Our reference: P-664517-PIL7
Contact: Sandra Fagan
Telephone: (02) 4732 7992

22 April 2024

**Council Response to Environmental Impact Statement – SSD-30628110
Summit at 706–752 Mamre Road, Kemps Creek**

Figure 2: Typical retaining wall section in fill

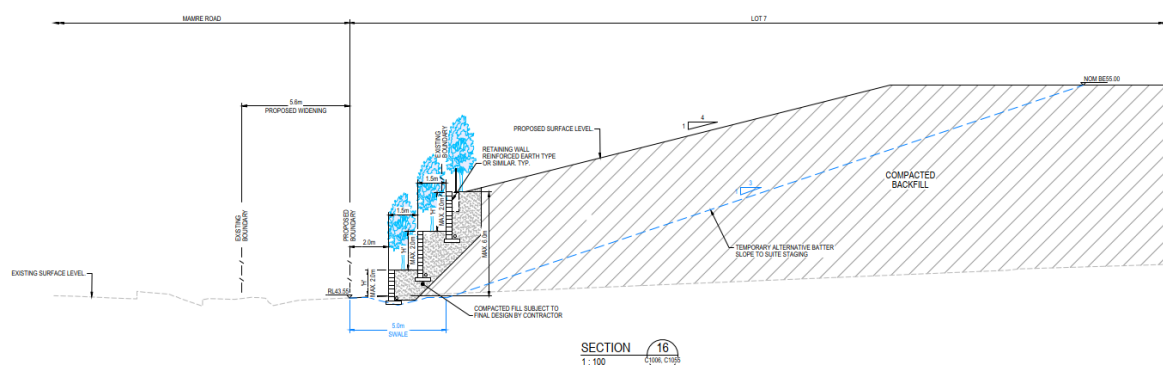
- i) The proposed retaining wall located adjacent to warehouse 1 and the low flow trunk drainage corridor does not appear to be tiered, given that it is a high retaining wall (6m high in part) with only a 1.5m setback at the top of wall.

Drawing Title:  
**Sections AA, BB & CC**  
DWG No:

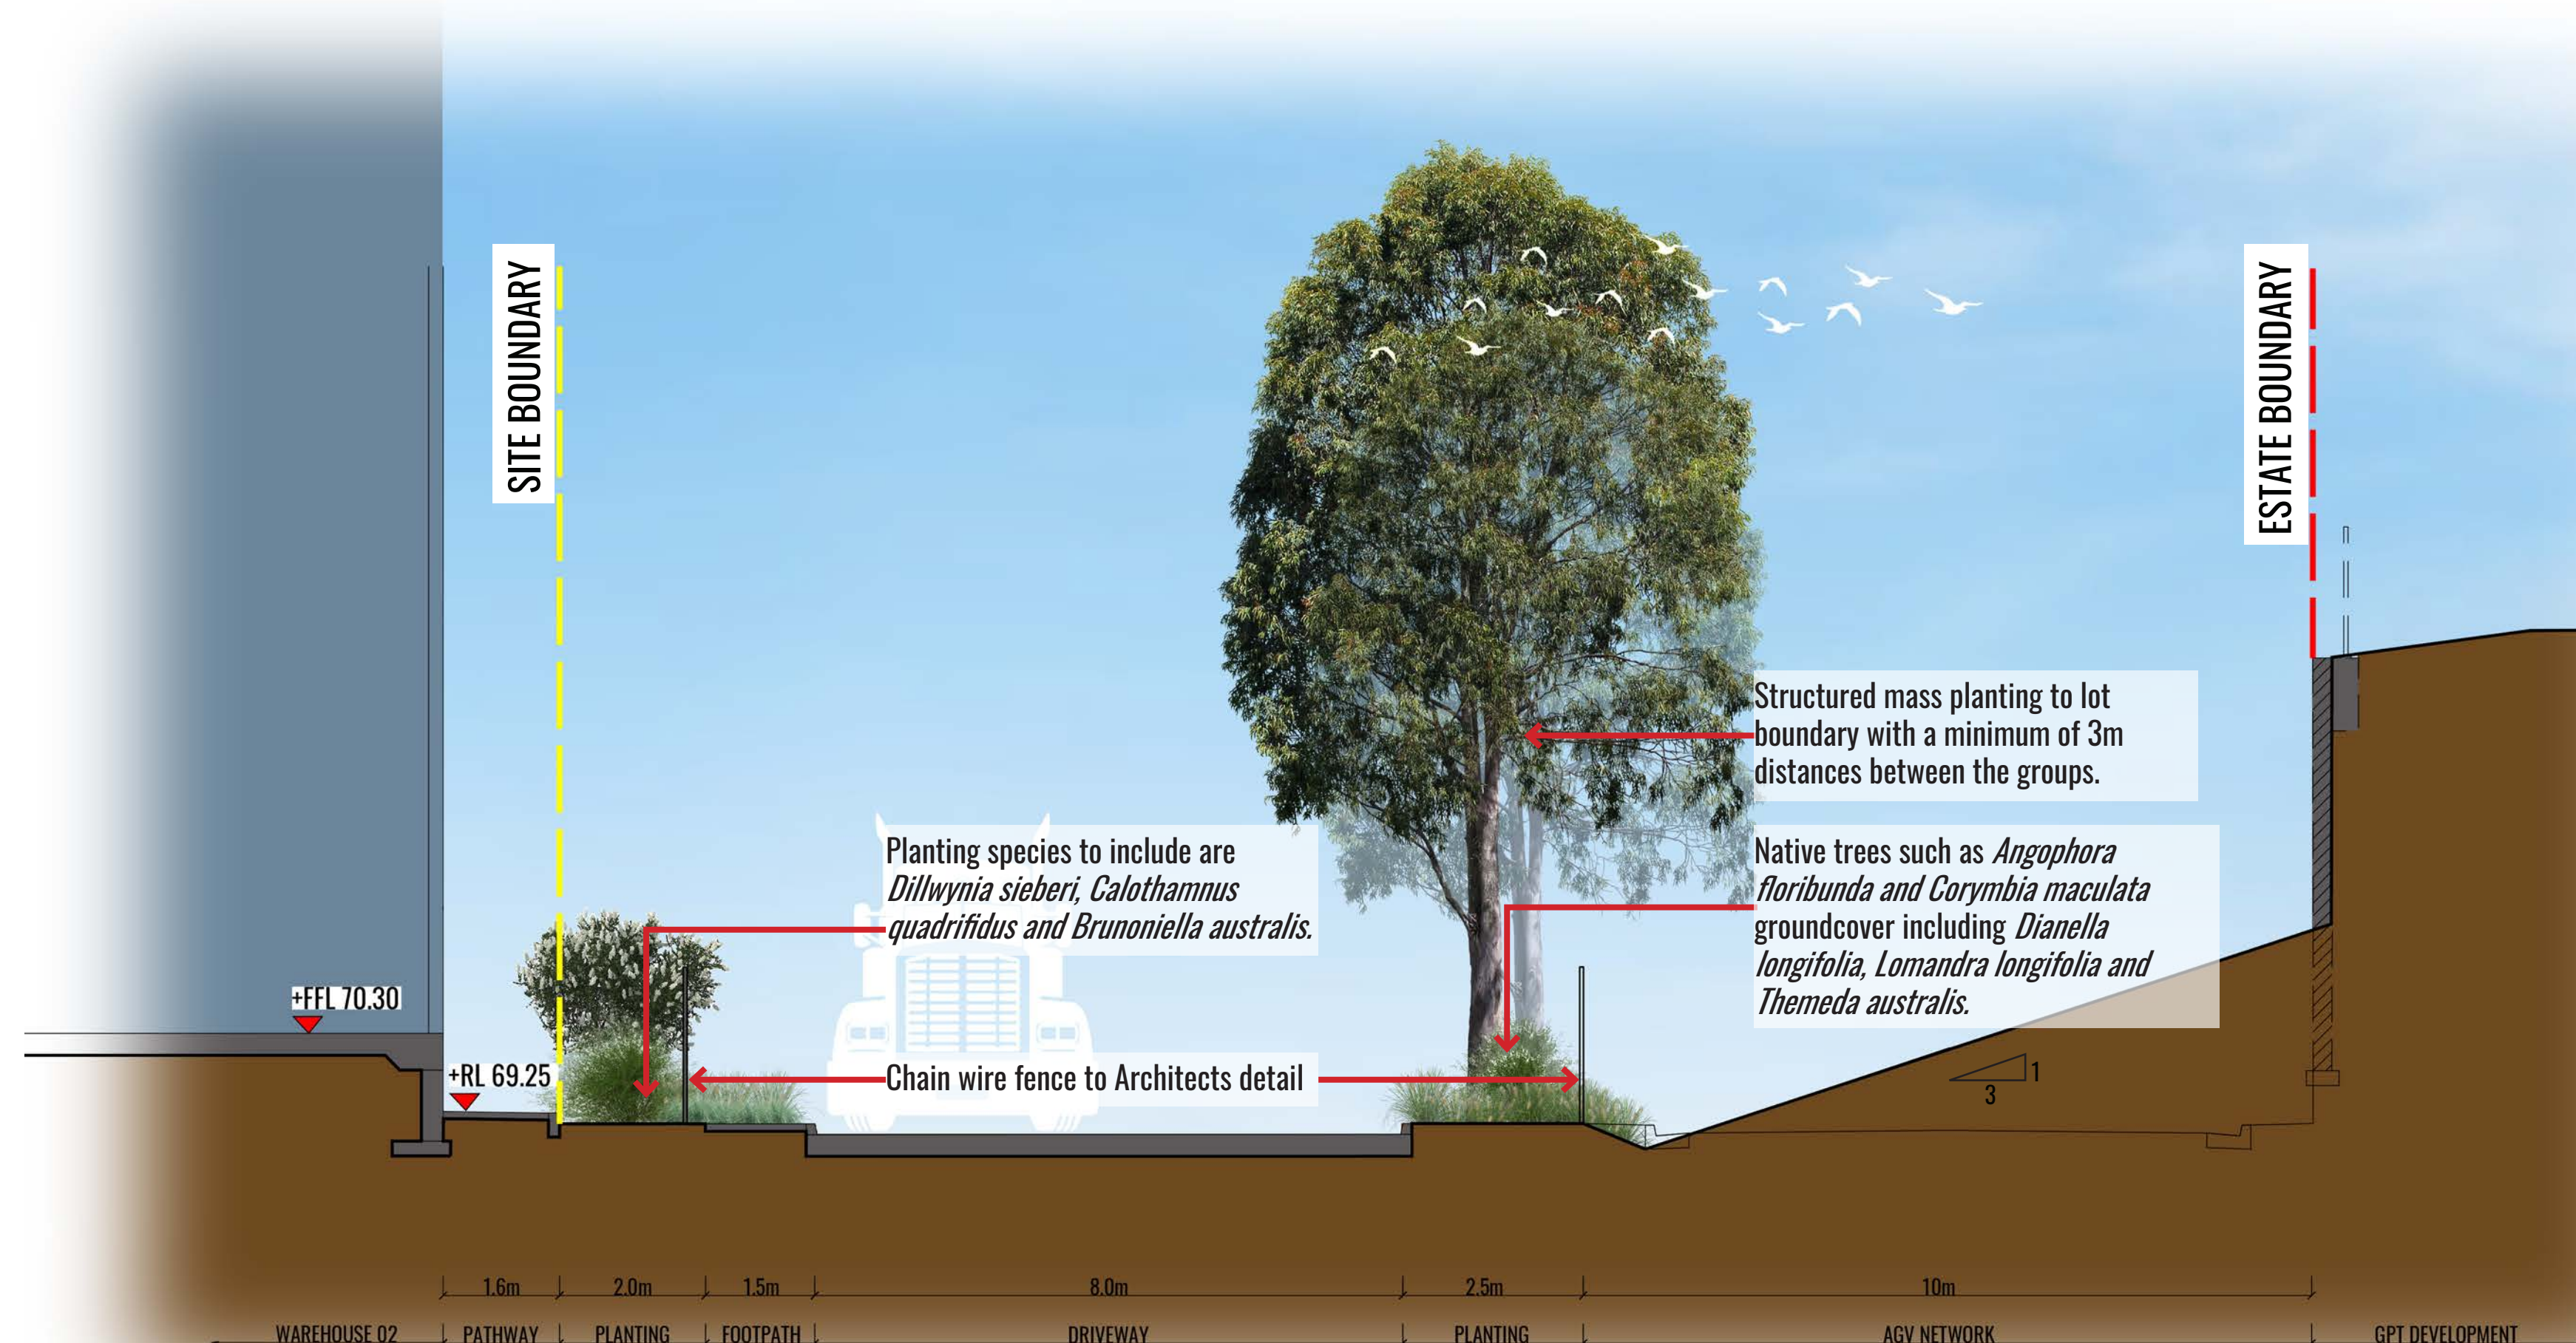
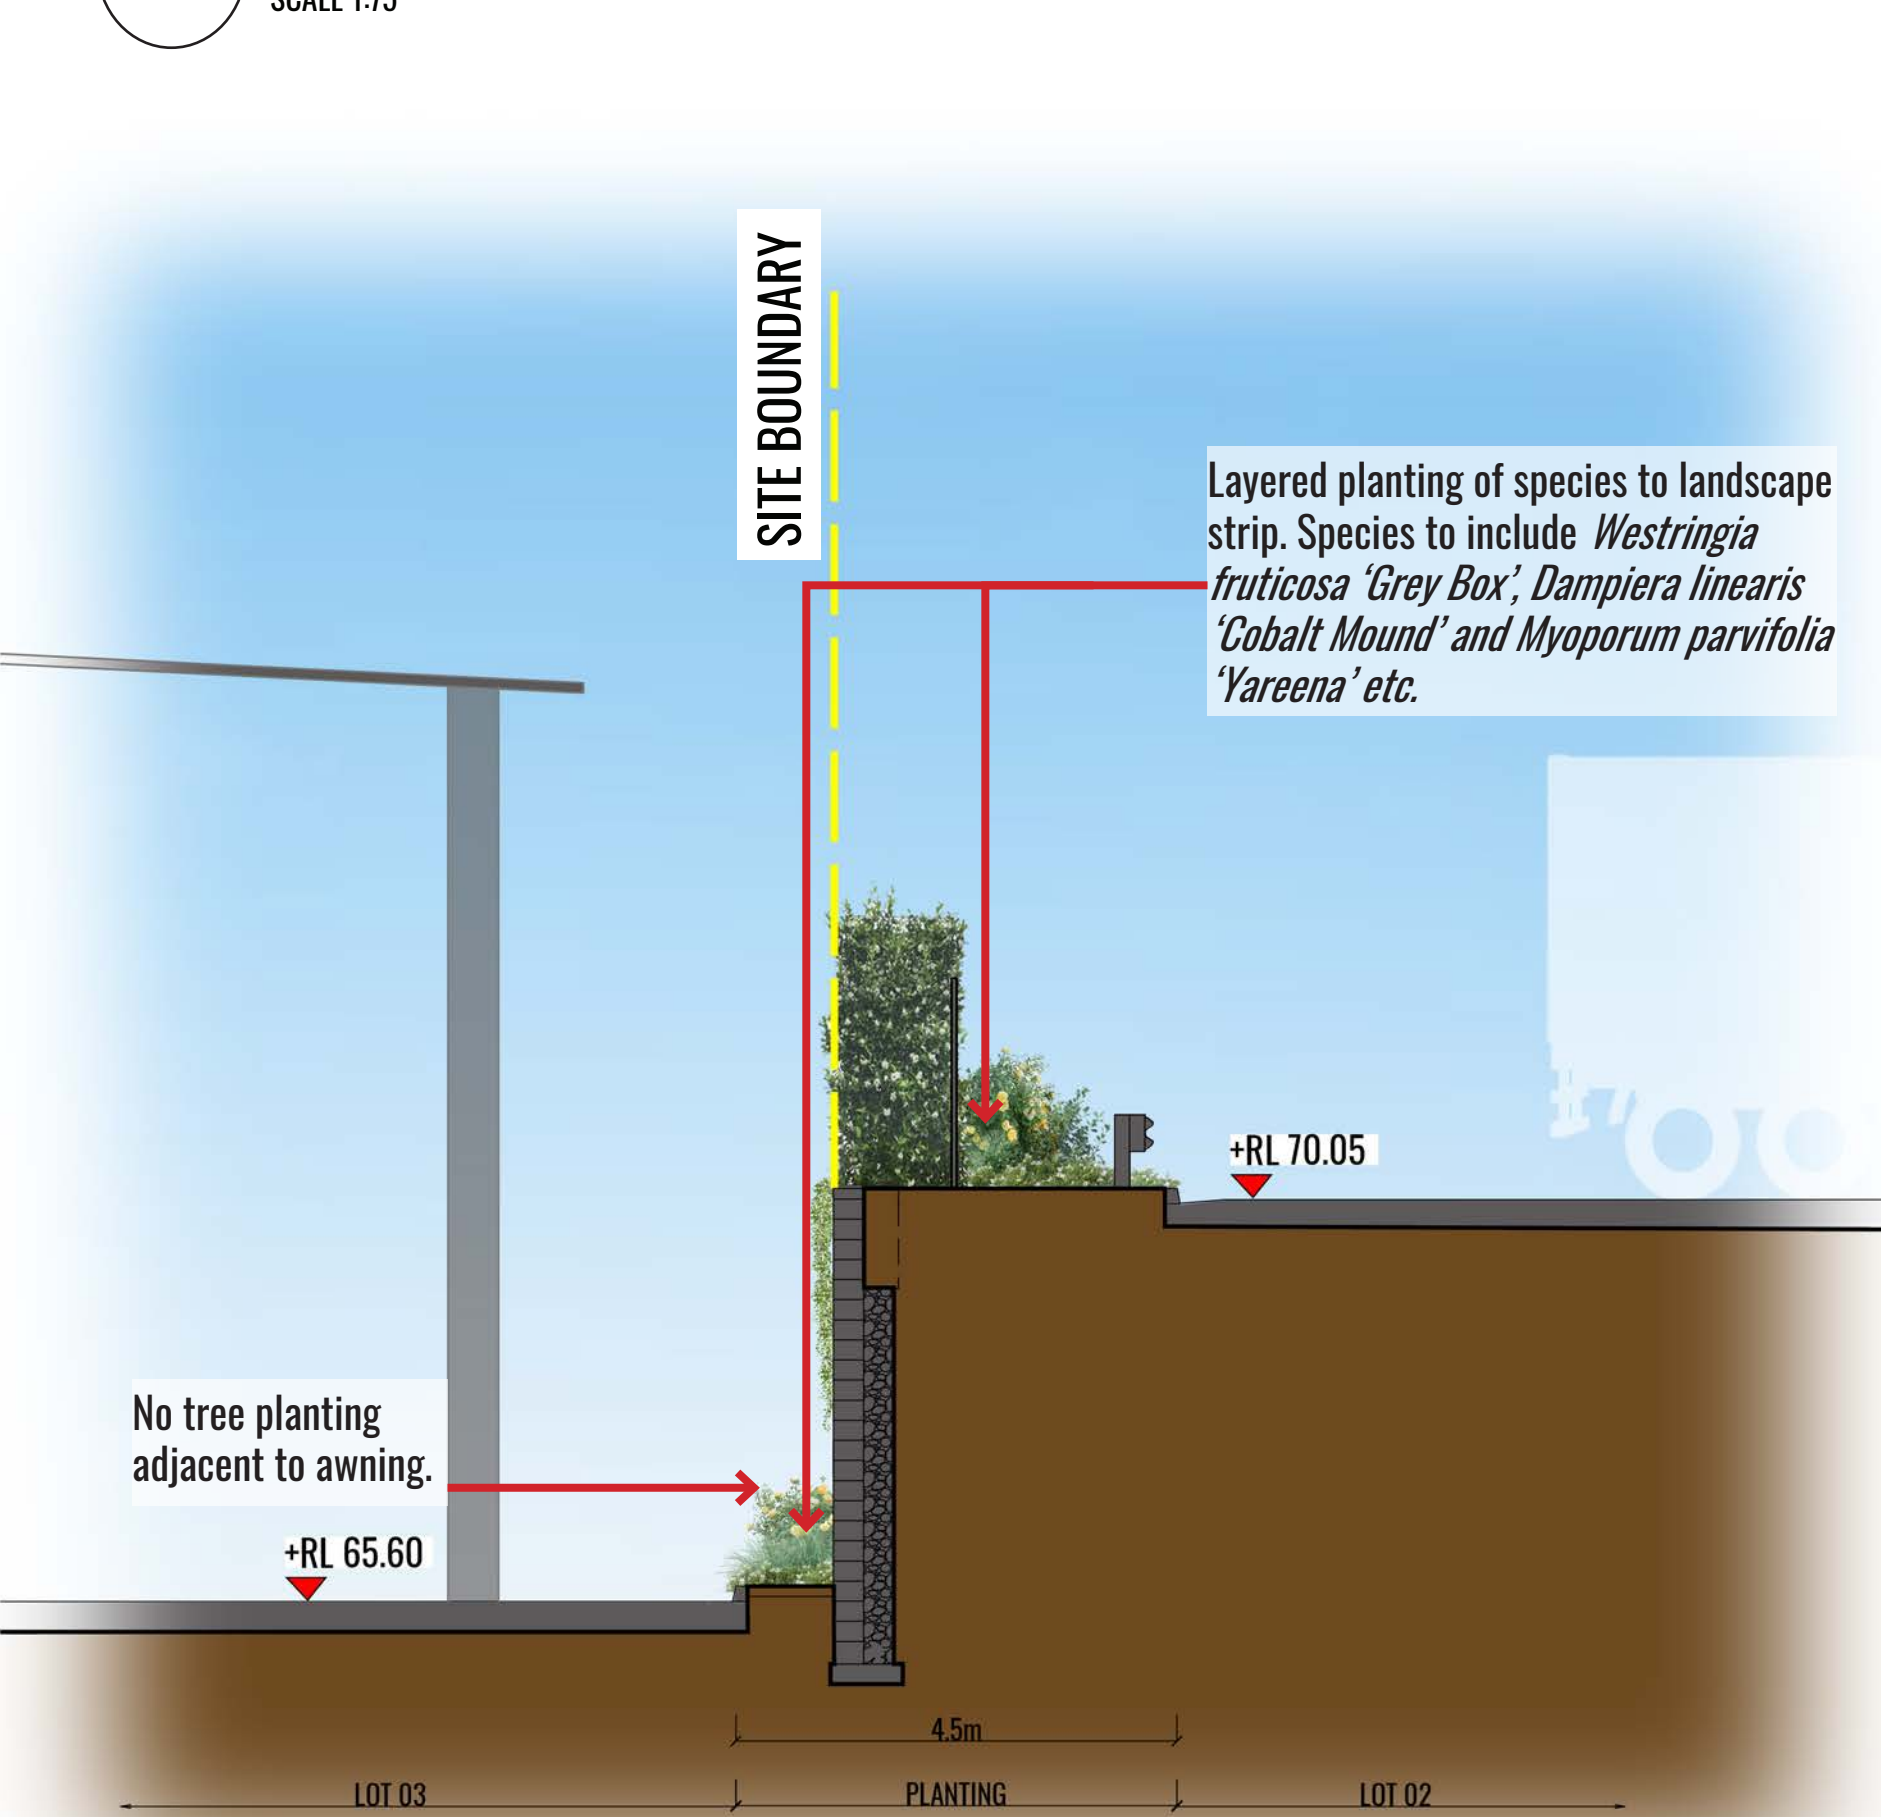
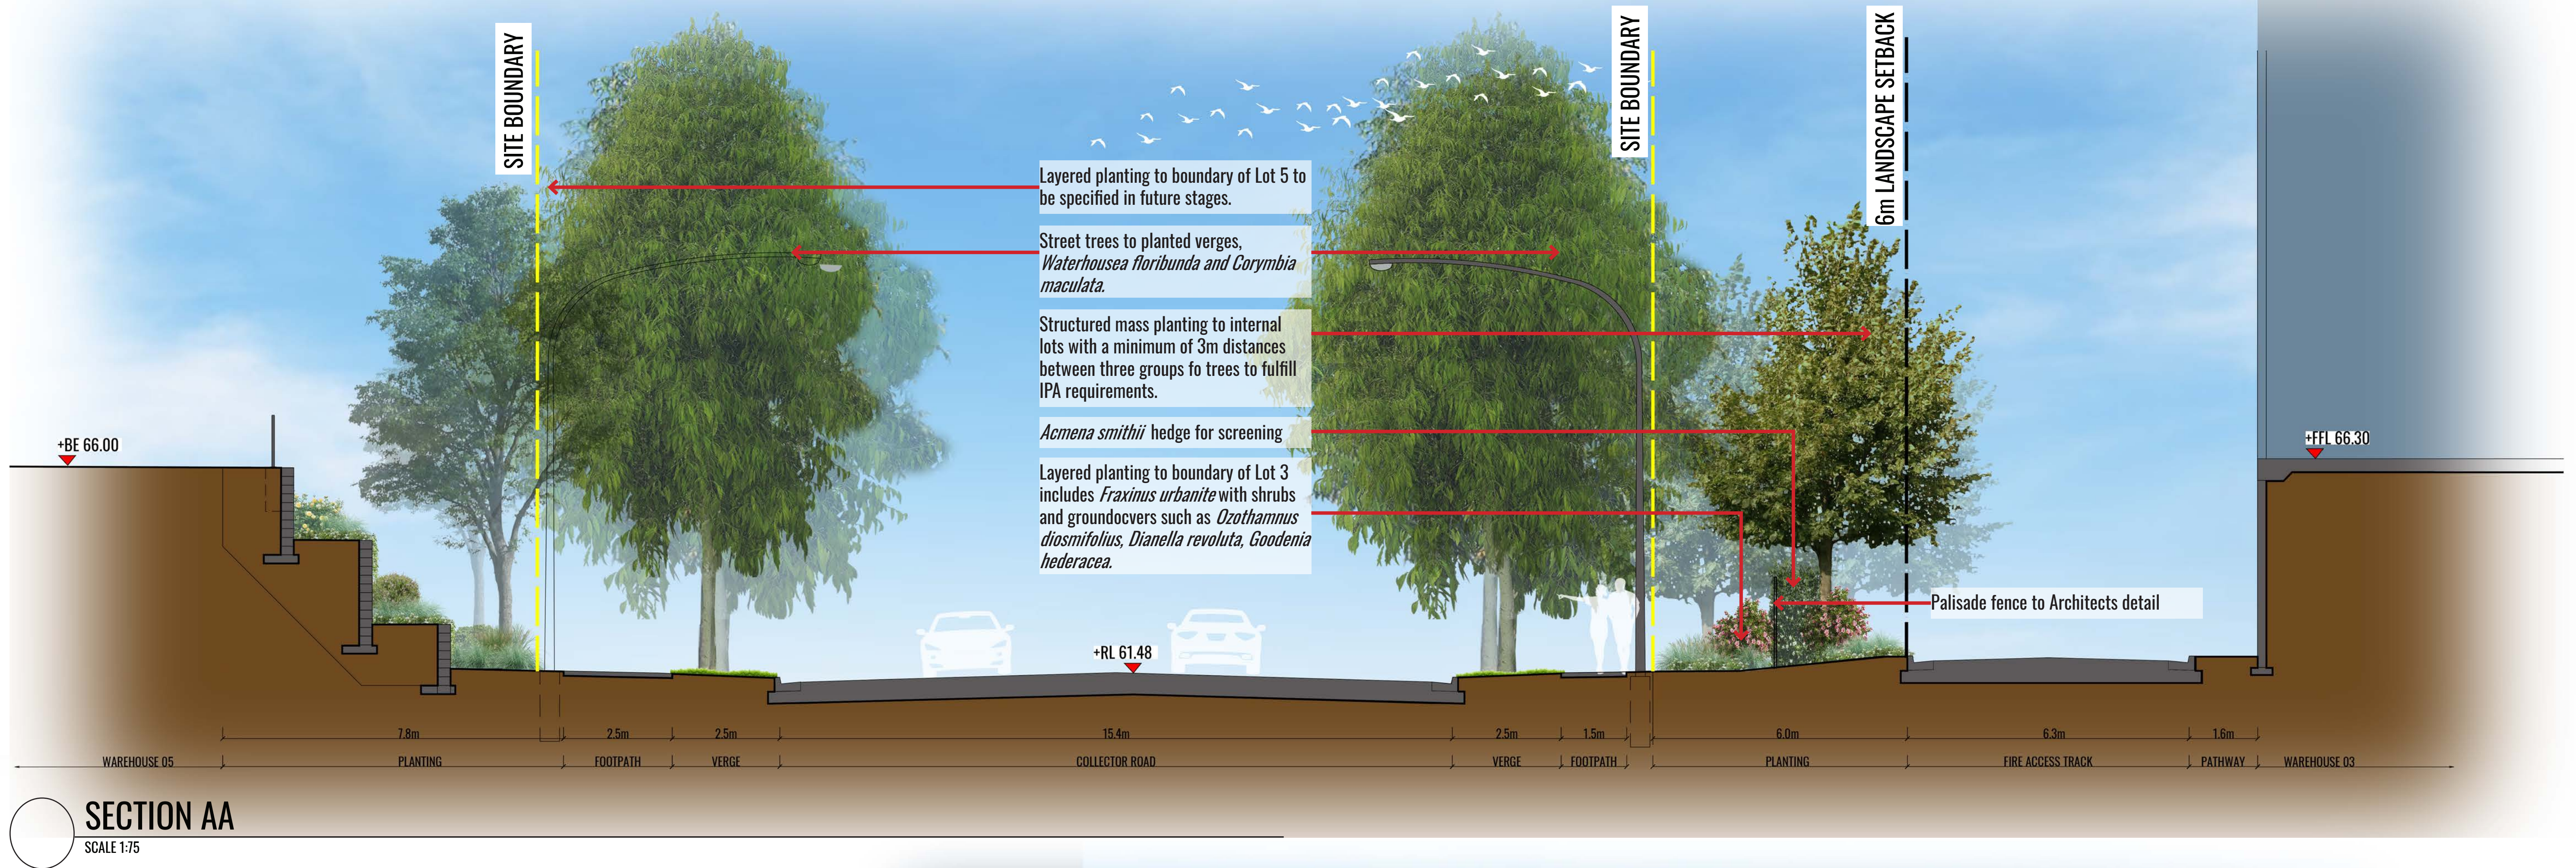
- h) DPHI should also consider whether the width, depth (and volume) of the deep soil area at the top of walls is sufficient to accommodate long-term growth of healthy, mature trees. Drawing sections 15, 16, and 17 show top of wall widths being 1.5m, which may comply with the MRP DCP. However, DPHI should consider if further landscaped setbacks along Mamre Road and Bakers Lane is necessary given the extent of retaining walls and level differences proposed in those areas, which are main frontages to the site. An increased front setback for additional landscaping may provide justification for the (slight) height non-compliance to part of the proposed warehouse. This should also include consideration of the proposed estate entry signs and how the sign will fit within the proposed landscaping, particularly the estate entry sign near warehouse 1 which is 23m wide and 4.4m high.
